2021 Financial Assurance Estimate Form
(with pre-plat construction)

PROJECT INFORMATION		
Latigo Trails Fil 10	9/17/2021	SF-XX-XXX
Project Name	Date	PCD File No.

LATIGO TRAILS - FILING NO. 9
TYPICAL SECTIONS
SHEET 3 OF 13
JOB NO. 25175.02

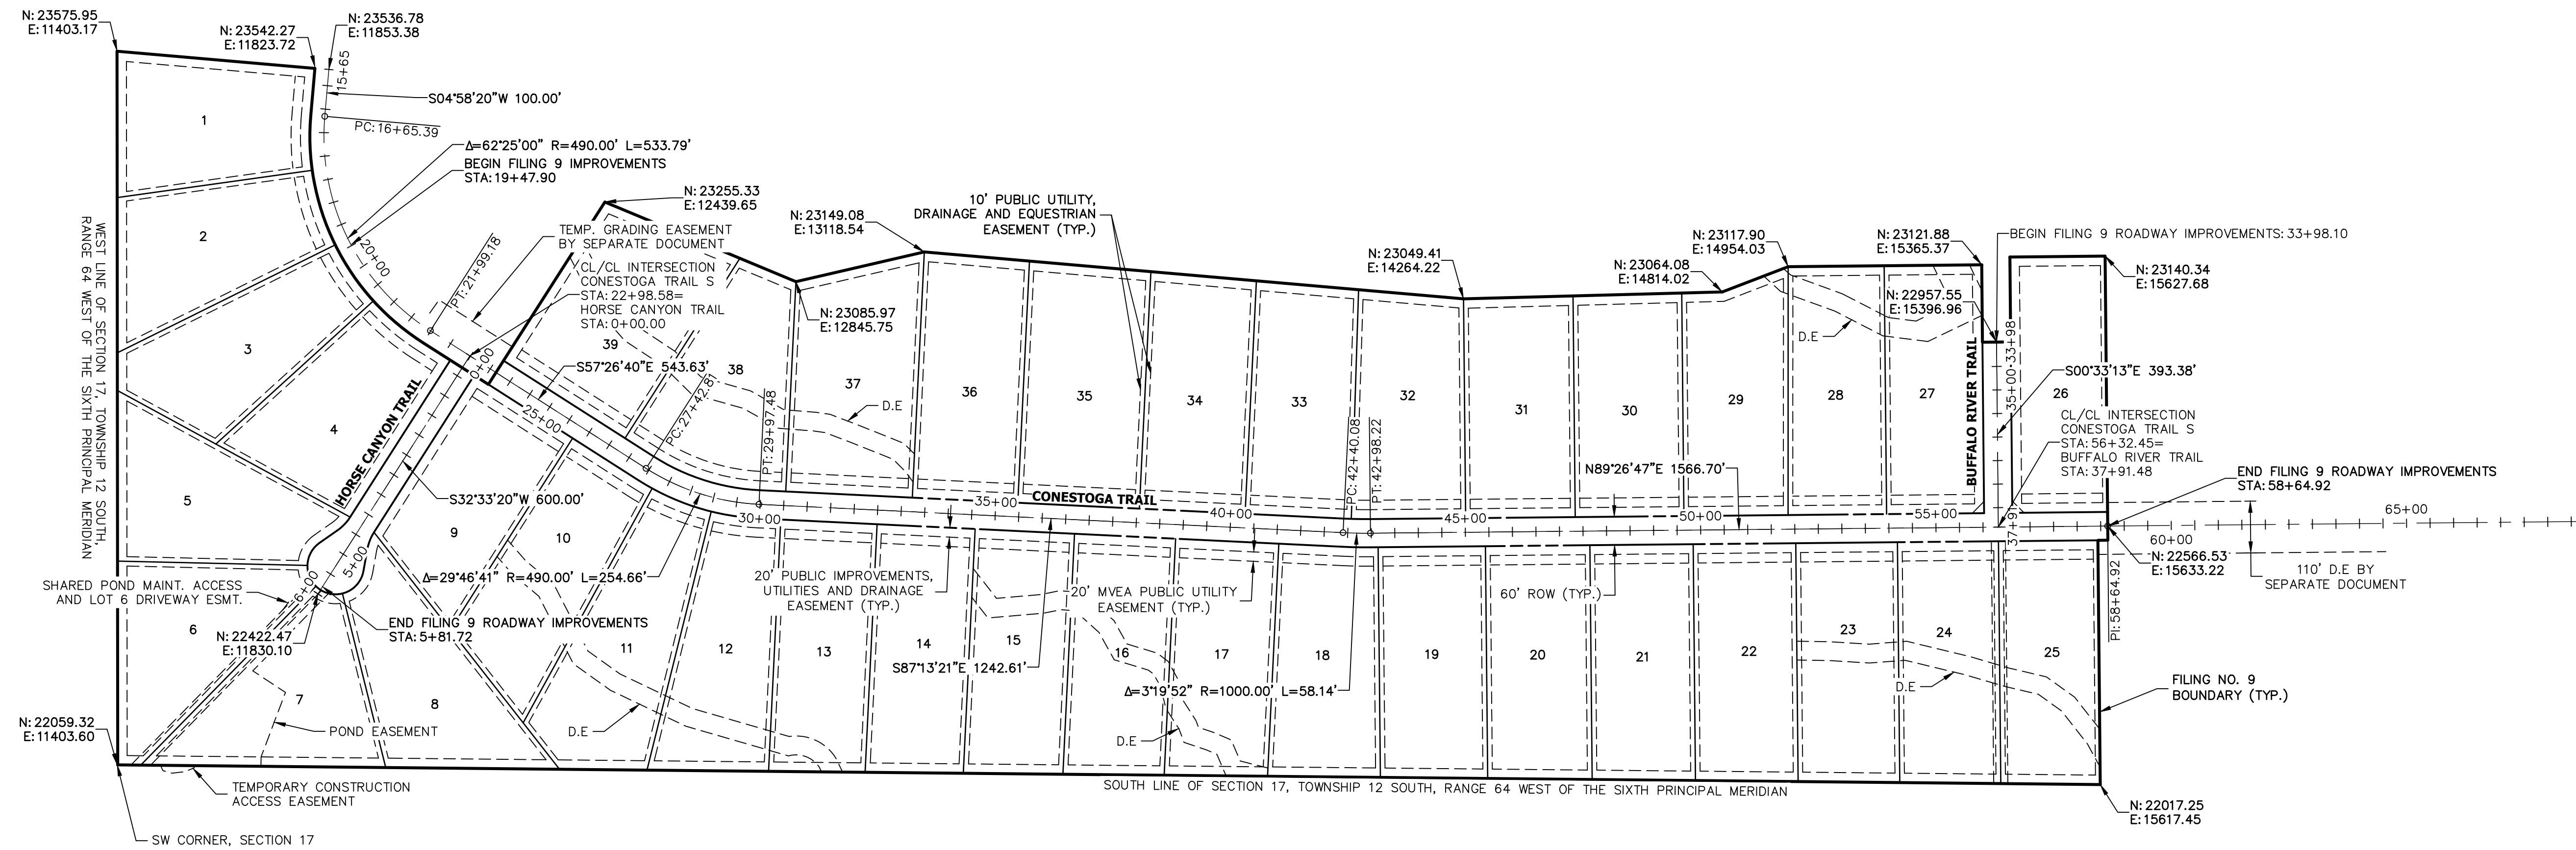
Revise. This quantity is low. Standard cross section requires a composite section with a minimum 4" base course under the asphalt.

LATIGO TRAILS – FILING NO. 9
SIGNAGE AND STRIPING PLAN
 SHEET 11 OF 13
 JOB NO. 25175.02

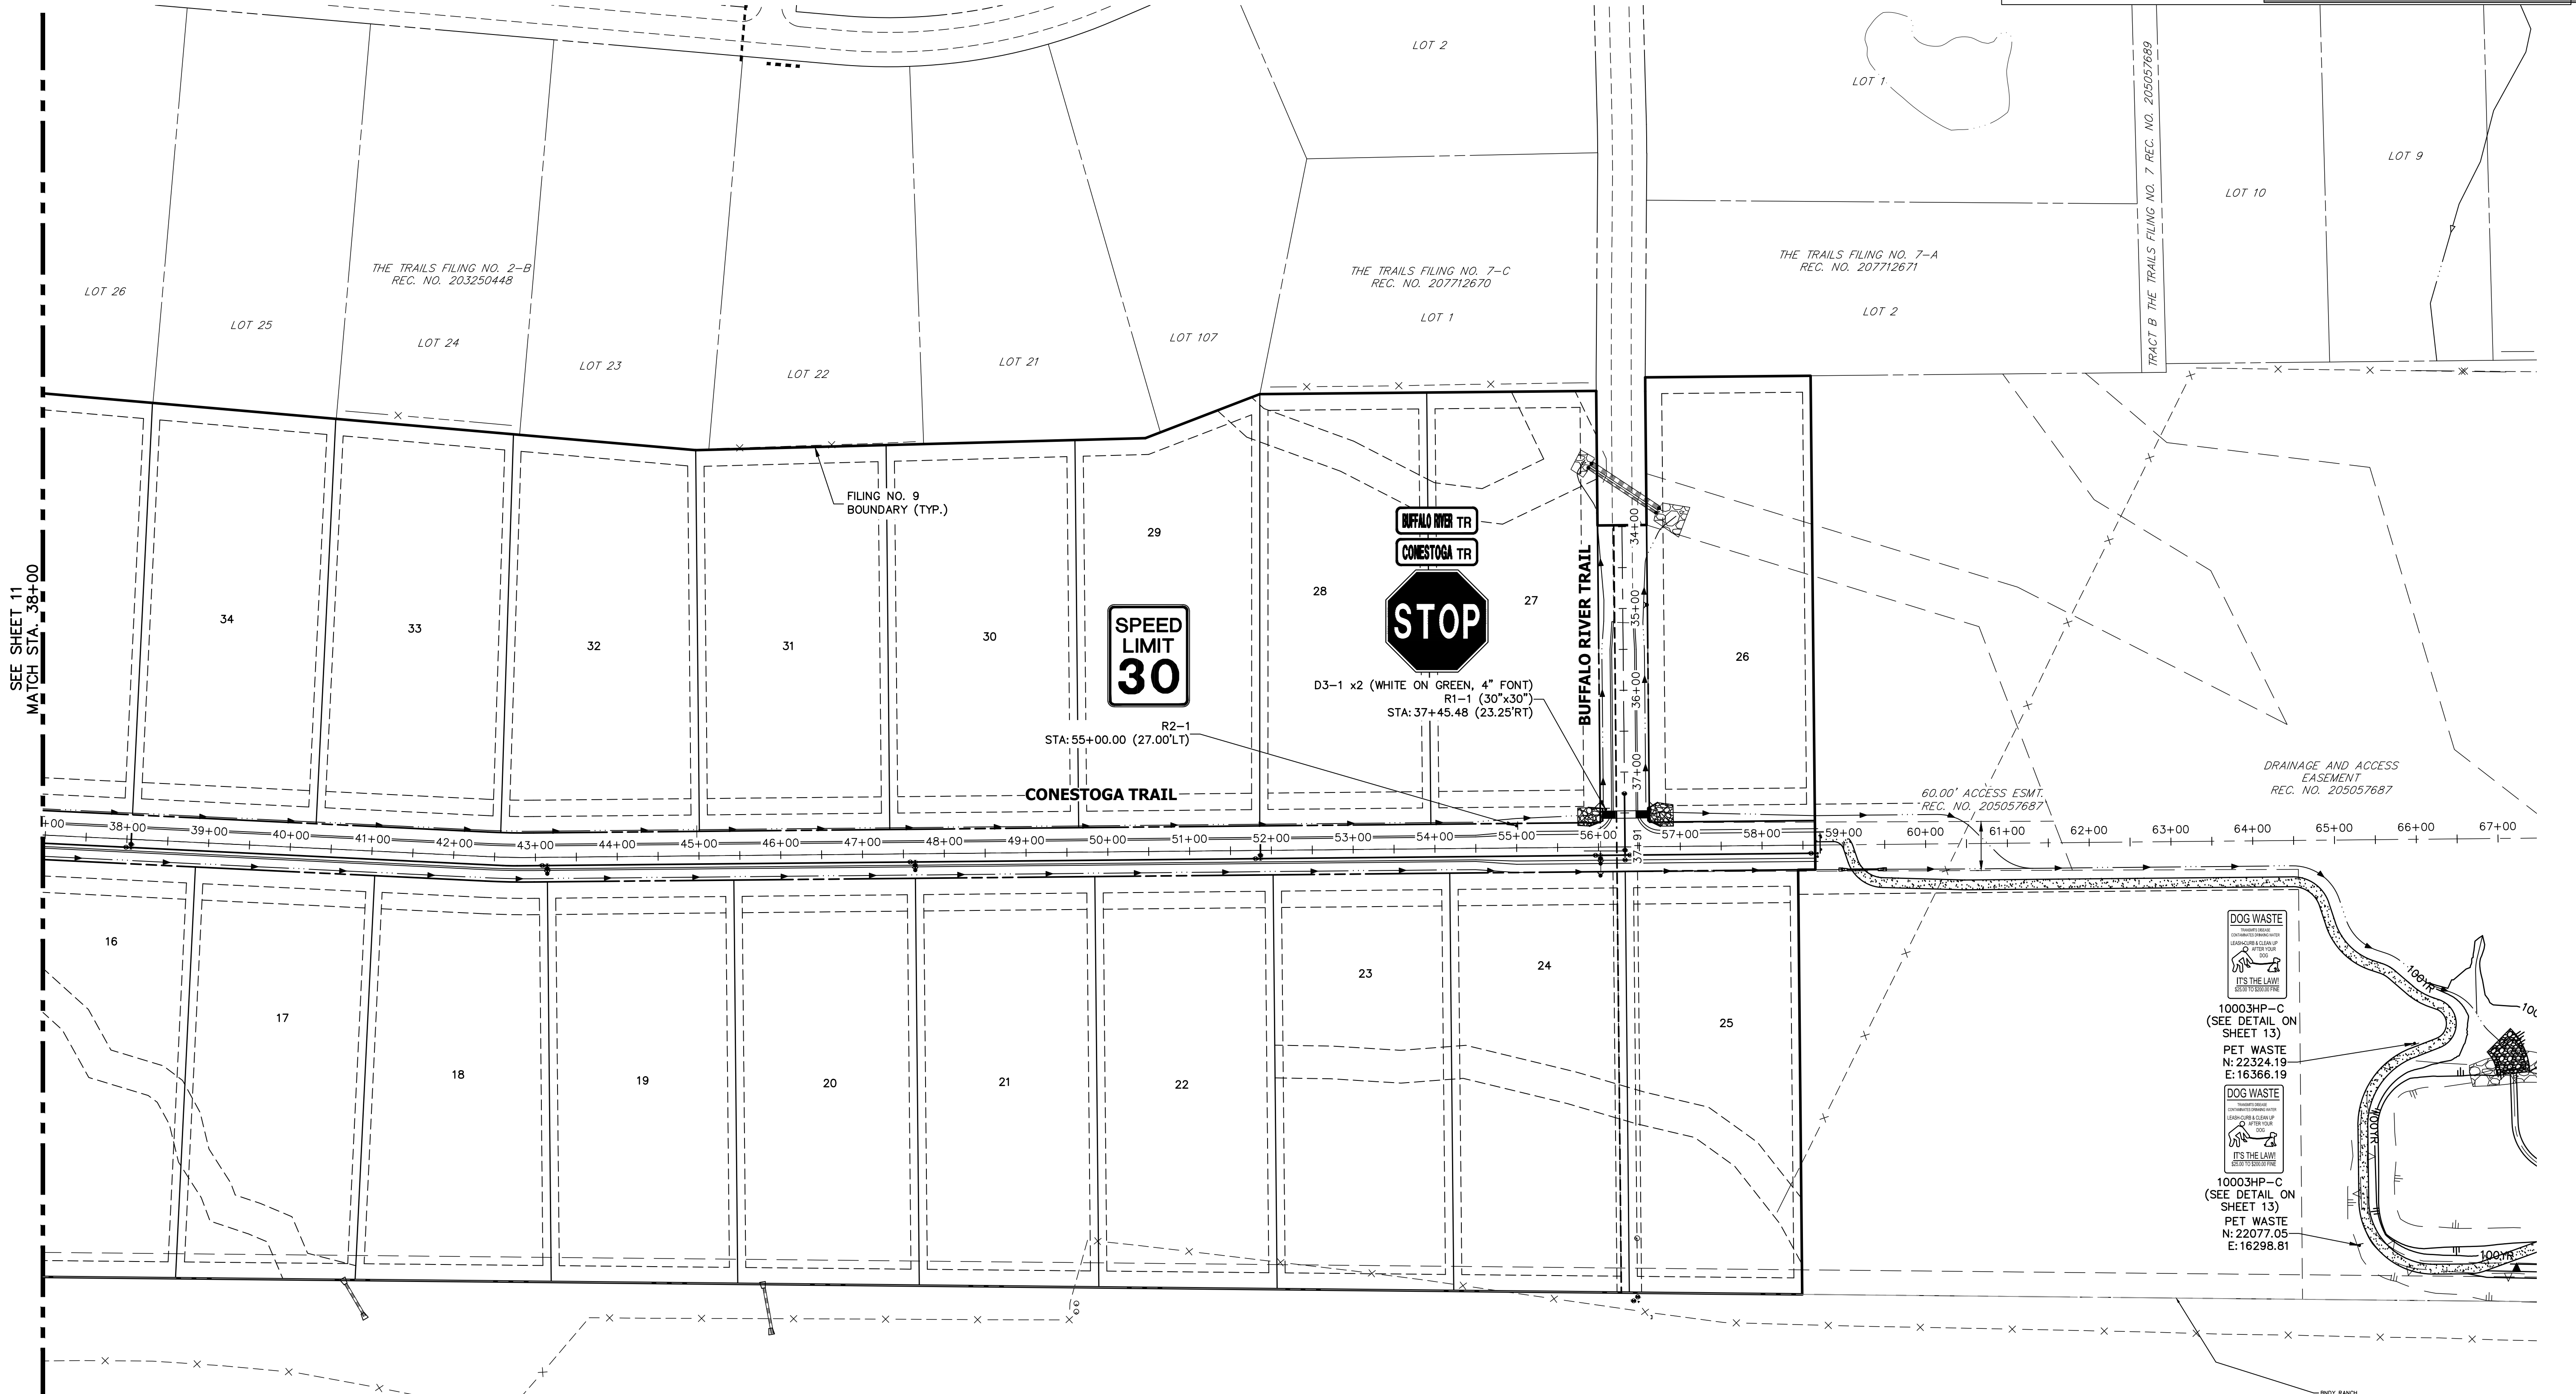
update the advisory sign per redline comments to the signage and striping plans
